**EL PASO COUNTY PLANNING AND
 COMMUNITY DEVELOPMENT
 DEPARTMENT**

STORMWATER MANAGEMENT PLAN CHECKLIST

Site: **A-1 Chipseal** Location: **7245 Cole View** **COM-22-014**

**SAND FILTER DESIGN - PLAN VIEW**  
N.T.S.

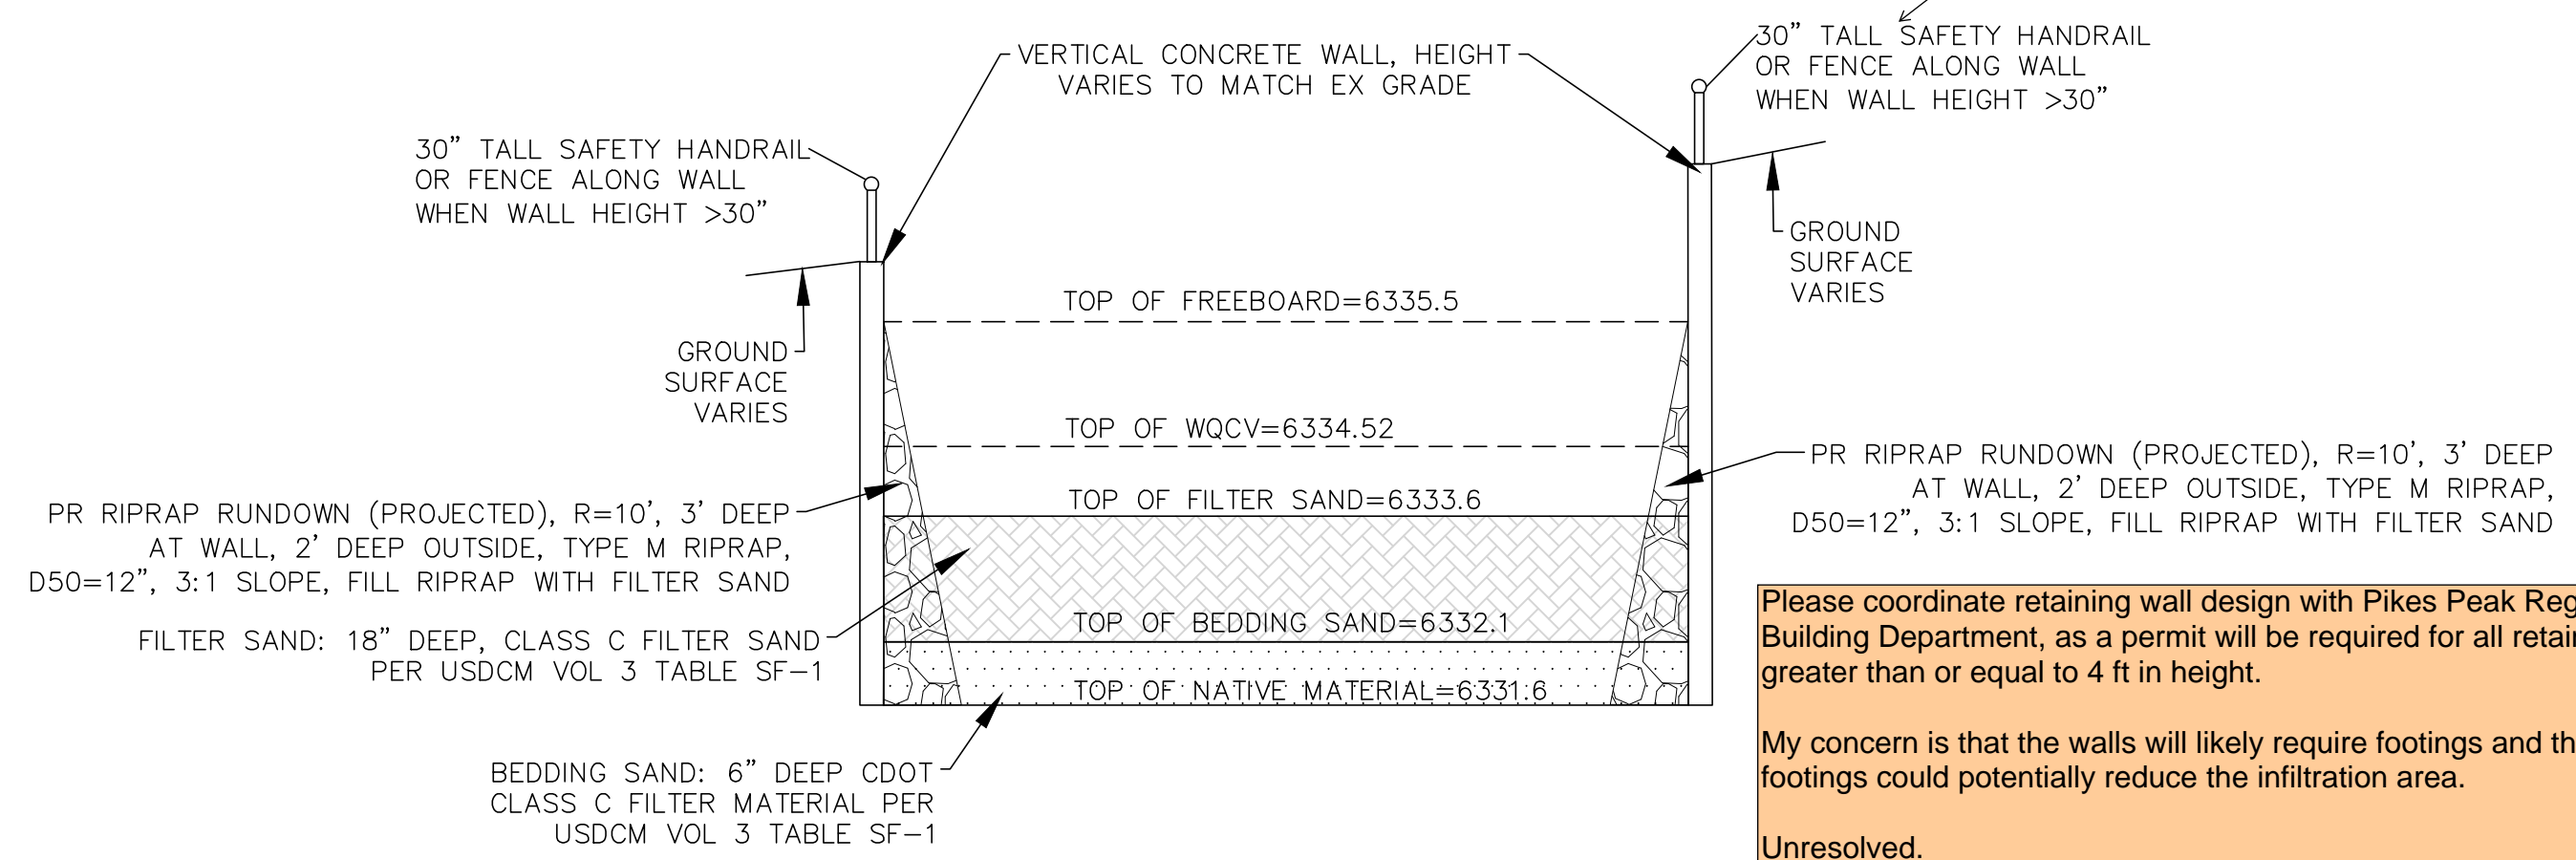
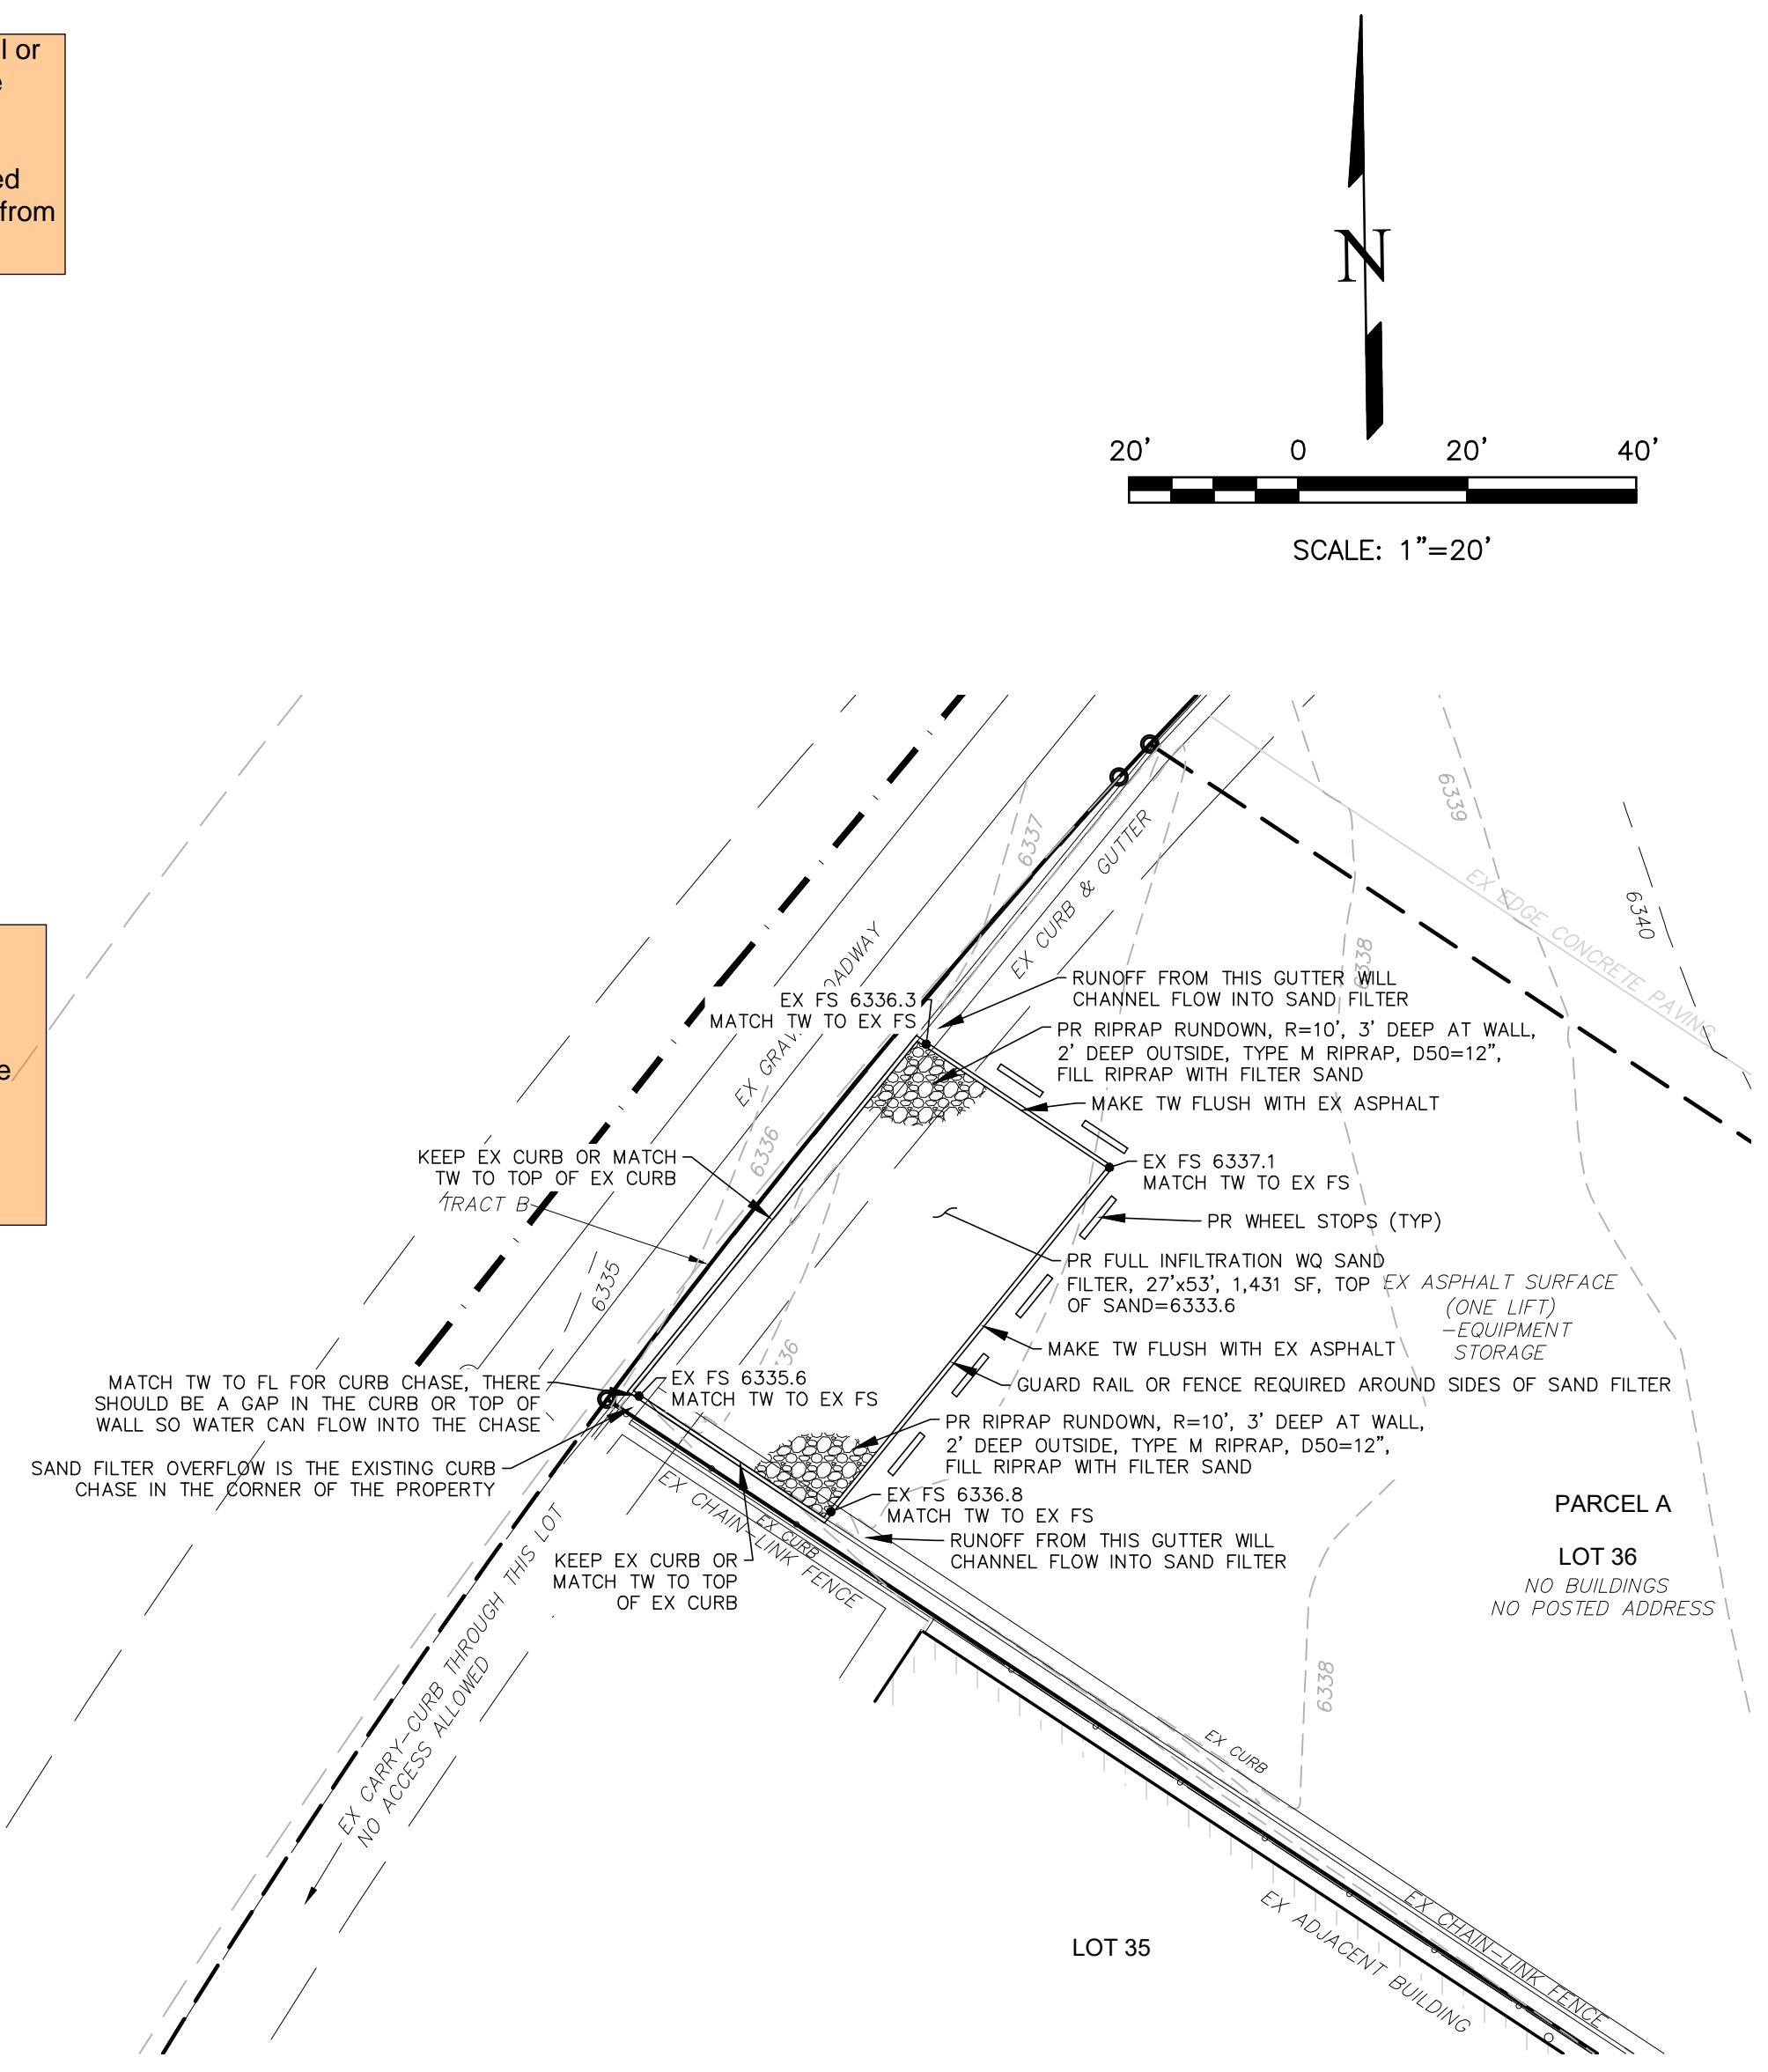
20	Technical drawing details for all control measure installation and maintenance; custom or other jurisdiction's details used must meet or exceed EPC standards	X	X
21	Procedure describing how the SWMP is to be revised	X	✓
22	Description of Final Stabilization and Long-term Stormwater Quality (describe nonstructural and structural measures to control SW pollutants after construction operations have been completed, including detention, water quality control measure etc.)	X	✓
23	Specification that final vegetative cover density is to be 70% of pre-disturbed levels	X	✓
24	Outline of permit holder inspection procedures to install, maintain, and effectively operate control measures to manage erosion and sediment	X	✓
25	Record keeping procedures identified to include signature on inspection logs and location of SWMP records on-site	X	✓
26	If this project relies on control measures owned or operated by another entity, a documented agreement must be included in the SWMP that identifies location, installation and design specifications, and maintenance requirements and responsibility of the control measure(s).	X	✓

KEY	TITLE	SYMBOL	IMPLEMENTATION PHASE
SSA	STABILIZED STAGING AREA		INTERIM
CWA	CONCRETE WASHOUT AREA		INTERIM
SS	STREET SWEEPING & VACUUMING		INTERIM

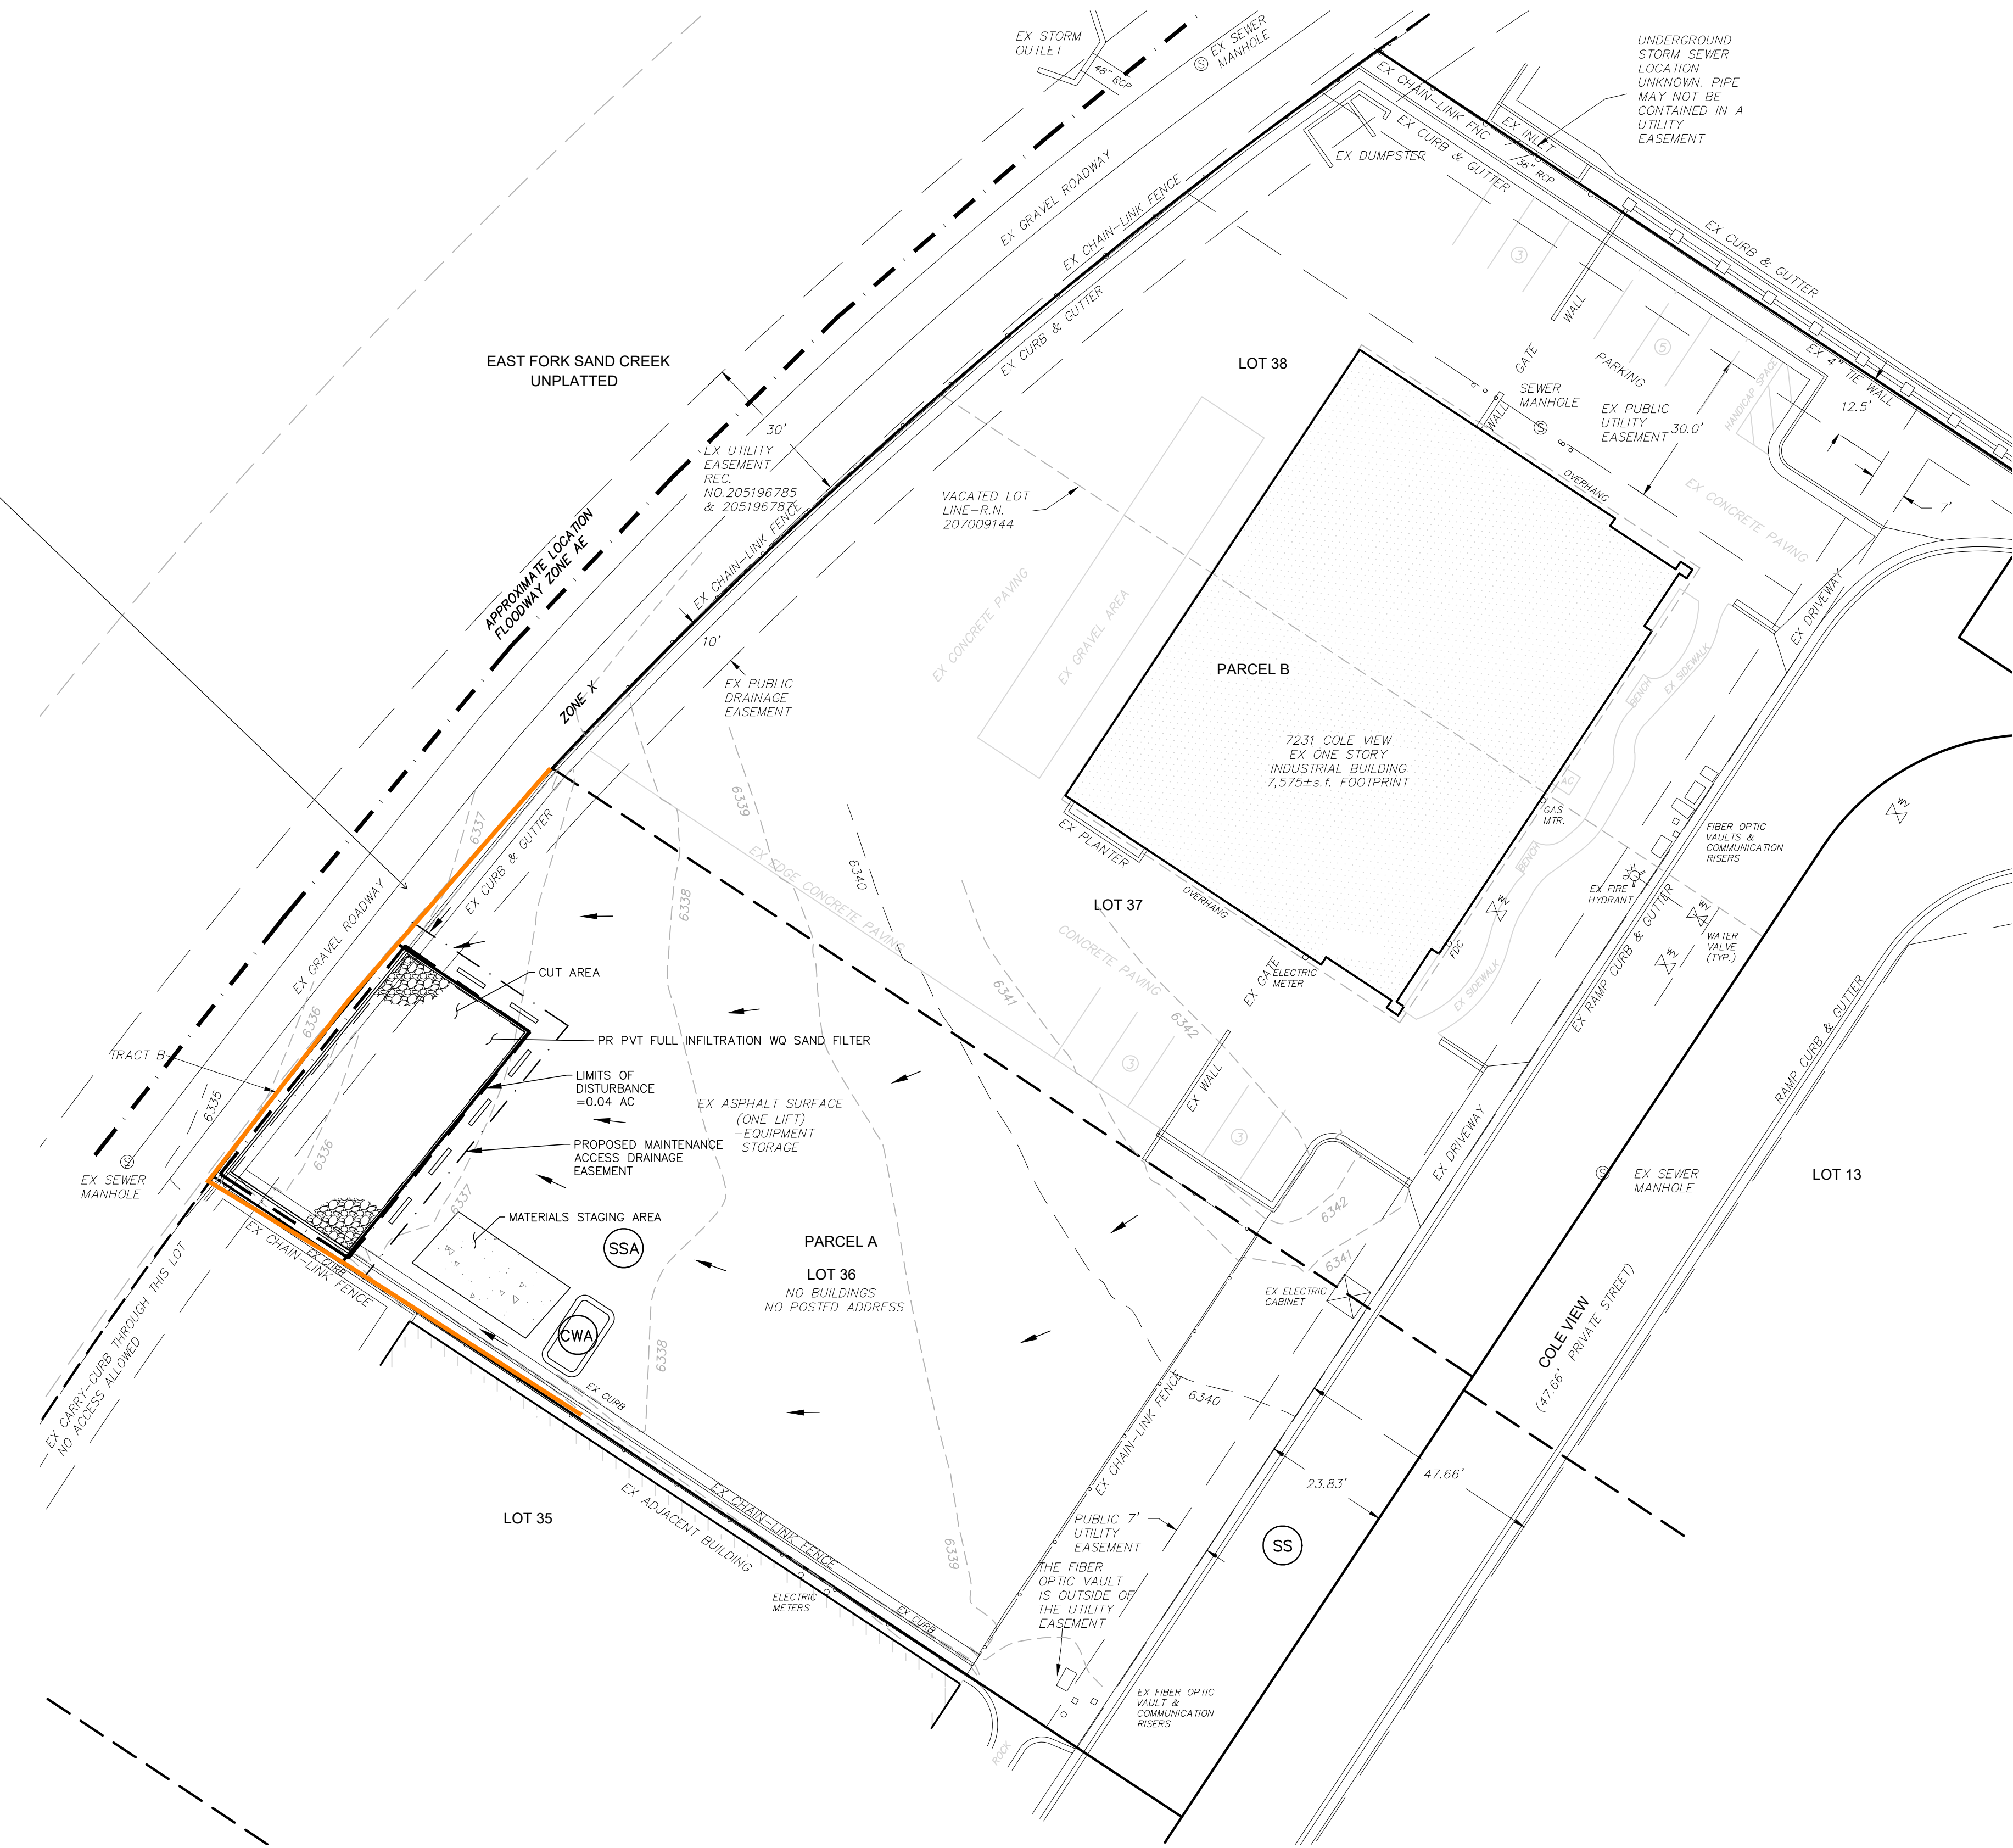
Applicant	PCD
17	SWMP Map to include:		
17a	construction site boundaries	X	✓
17b	flow arrows to depict stormwater flow directions	X	✓
17c	all areas of disturbance	X	X
17d	areas of cut and fill	X	✓
17e	areas used for storage of building materials, soils (stockpiles) or wastes	X	✓
17f	location of any dedicated asphalt / concrete batch plants	X	X
17g	location of all structural control measures	X	X
17h	location of all non-structural control measures	X	X
17i	springs, streams, wetlands and other surface waters, including areas that require maintenance of pre-existing vegetation within 50 feet of a receiving water	X	✓
18	Narrative description of all structural control measures to be used. Modifications to EPC standard control measures must meet or exceed County-approved details.	X	X
19	Description of all non-structural control measures to be used including seeding, mulching, protection of existing vegetation, site watering, sod placement, etc.	X	X
